Consultee Comment for planning application 25/02812/F

| Application Number | <input type="text" value="25/02812/F"/> |
| Proposal | <input type="text" value="Demolition of existing single storey extensions and garage and erection of new single and two storey extensions"/> |
| Organisation | <input type="text" value="Building Control (CDC)"/> |

Proposals

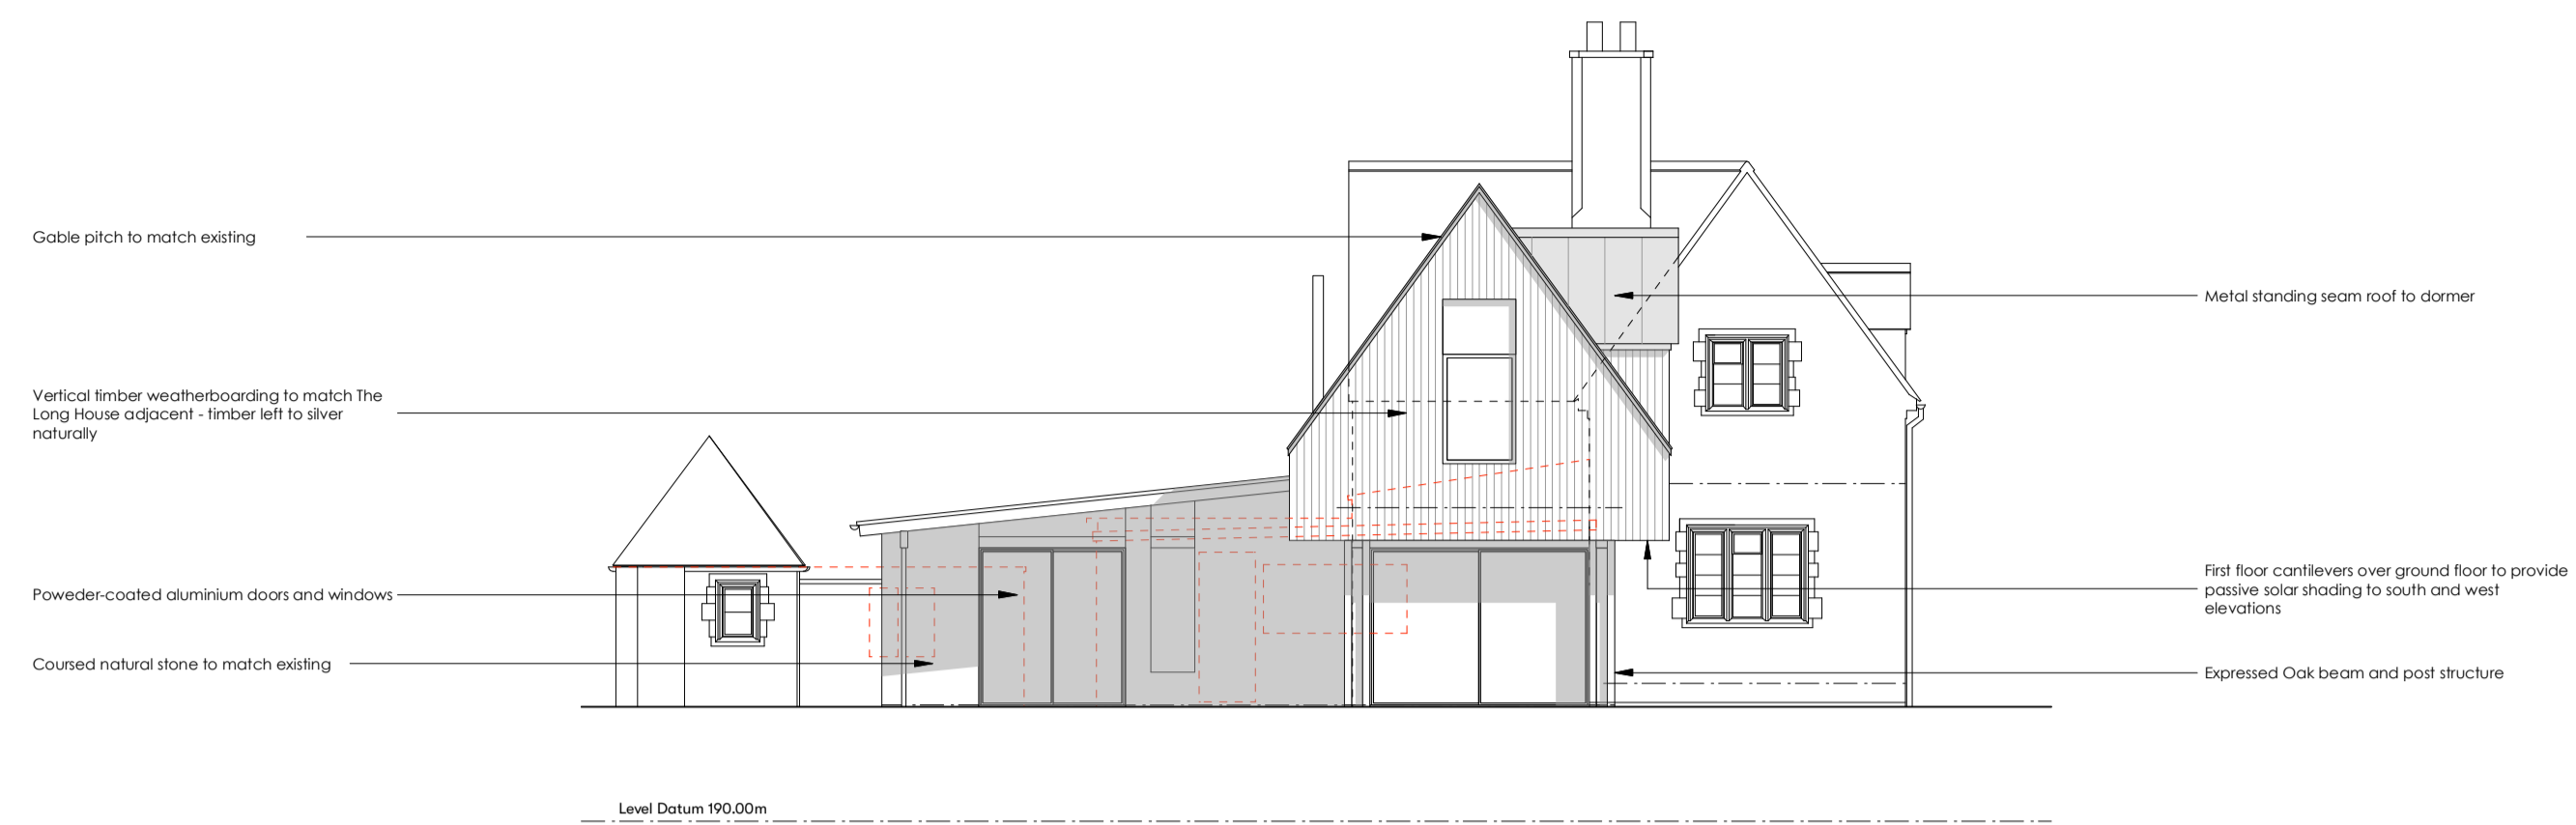
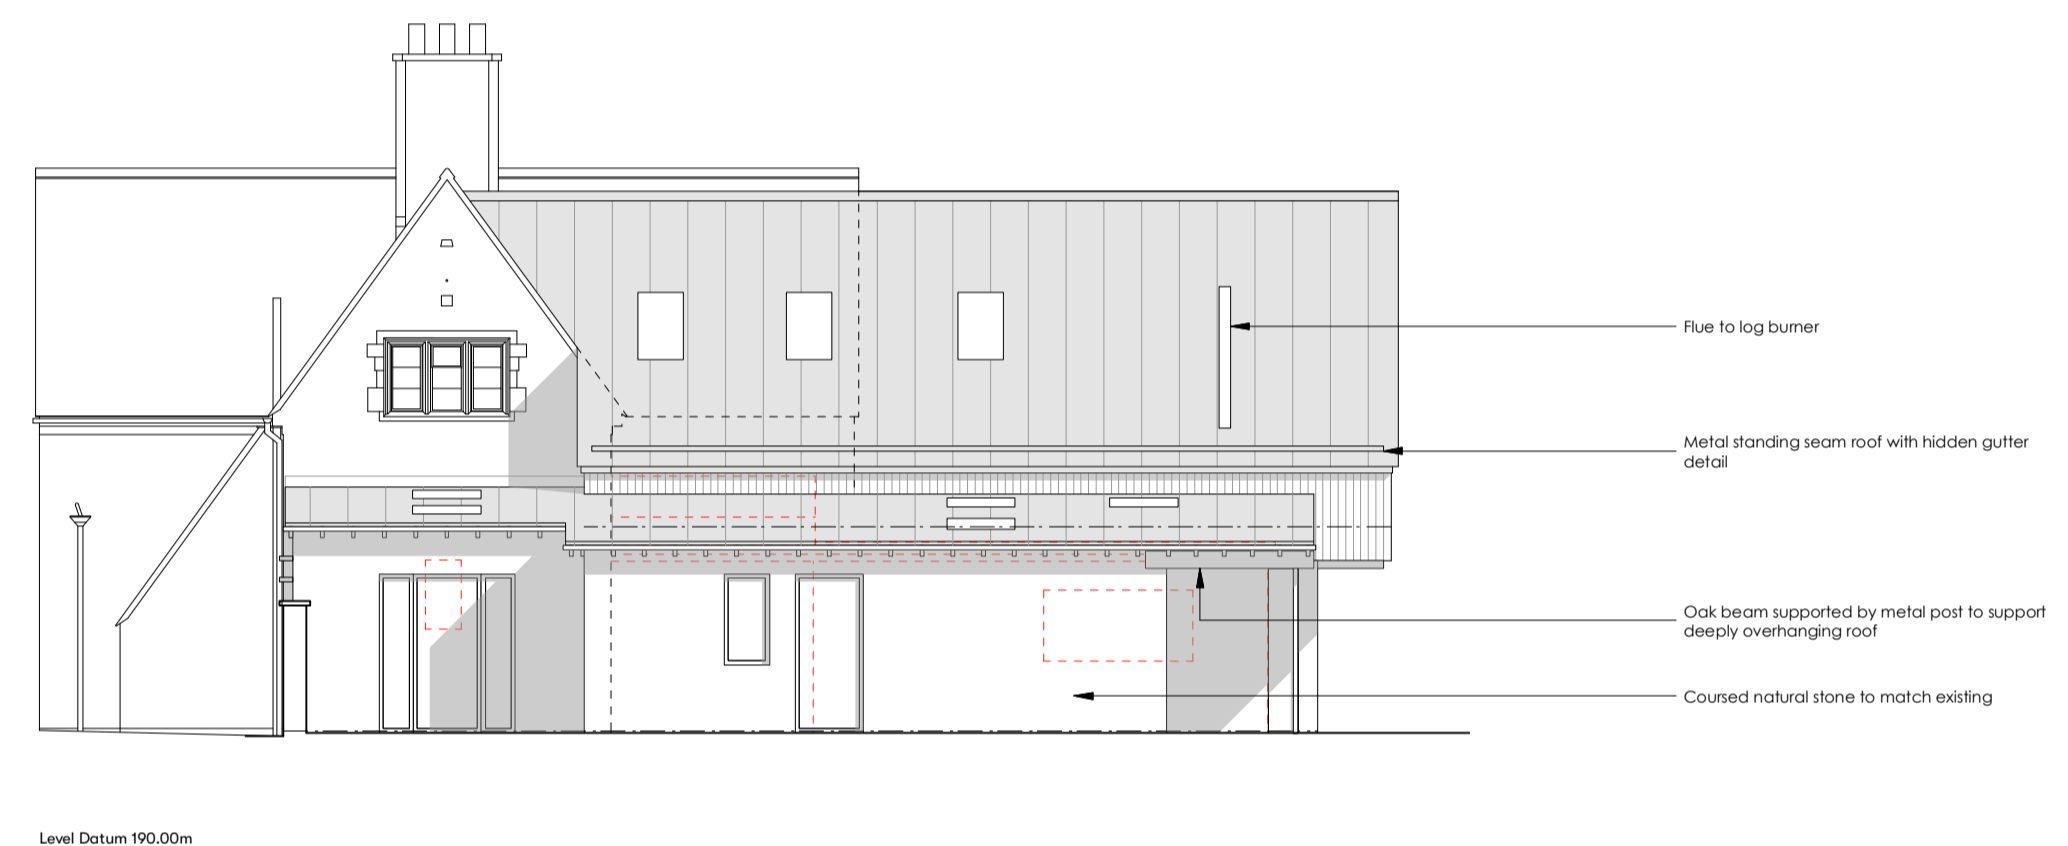
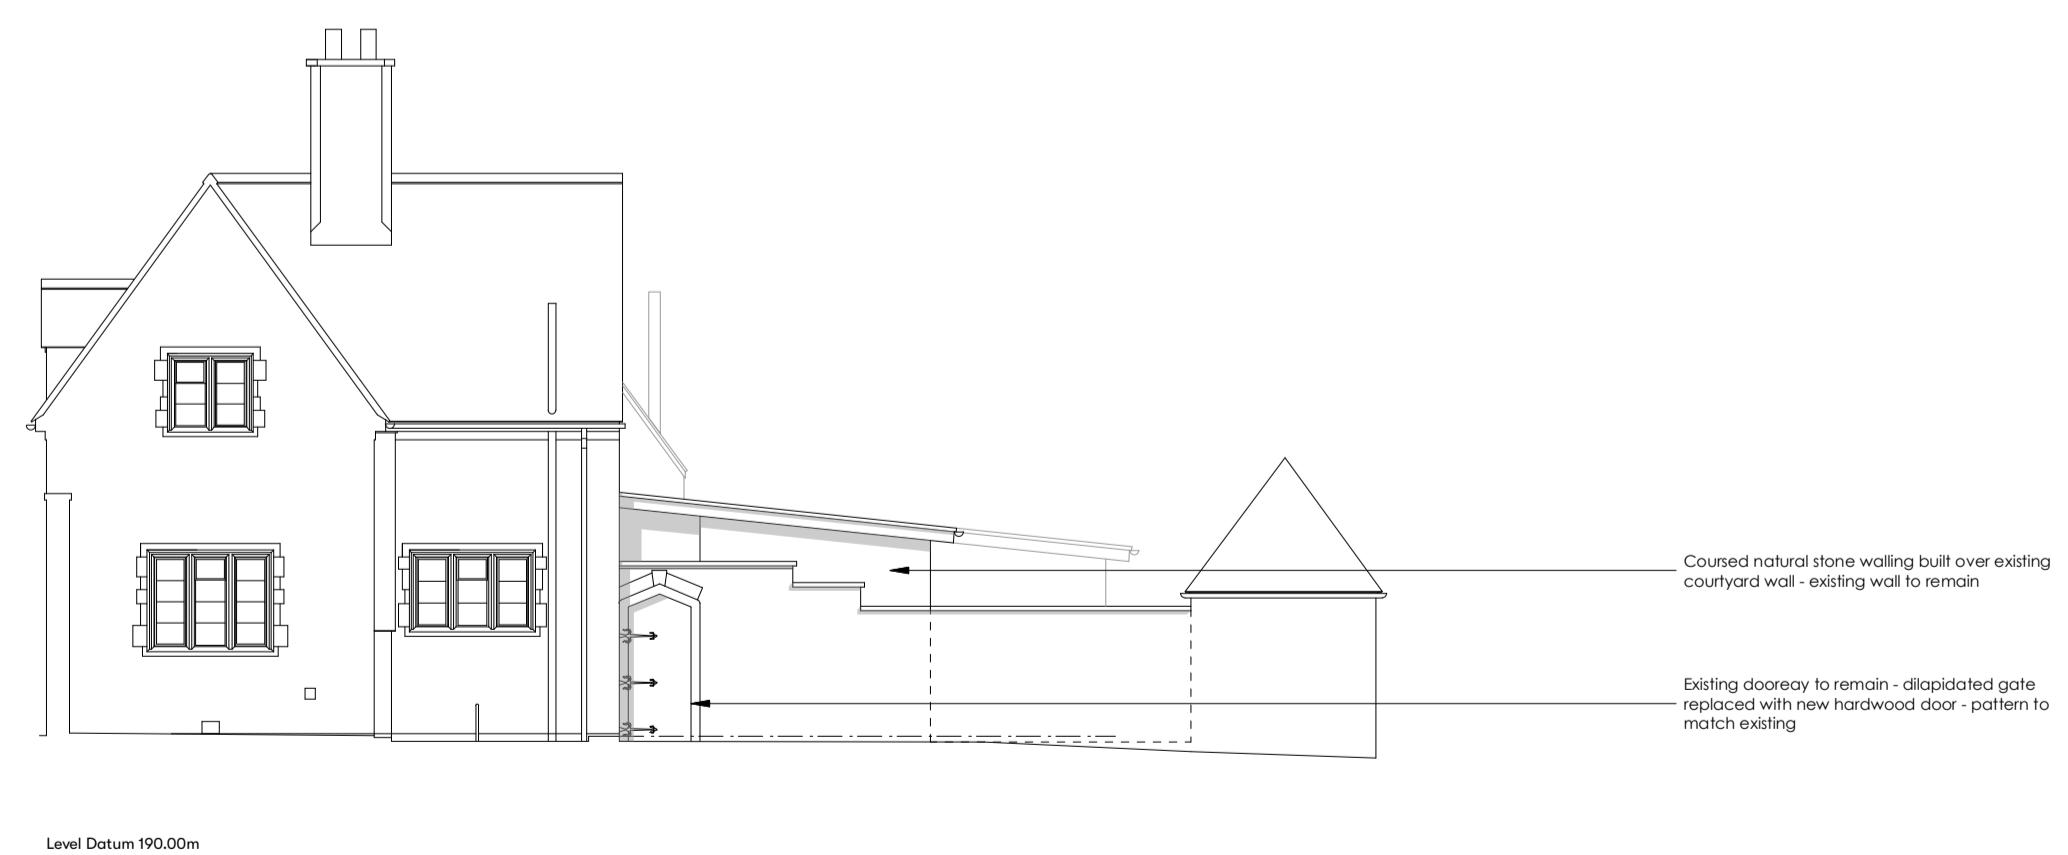
| Comments | <input type="text" value="The proposal is subject to the Building Regulations, and will require an application to be submitted to a Building Control body for approval. Please note that the flue for the wood-burning stove will need to be extended higher by about a metre or so (than shown in the elevation drawing), to comply."/> |
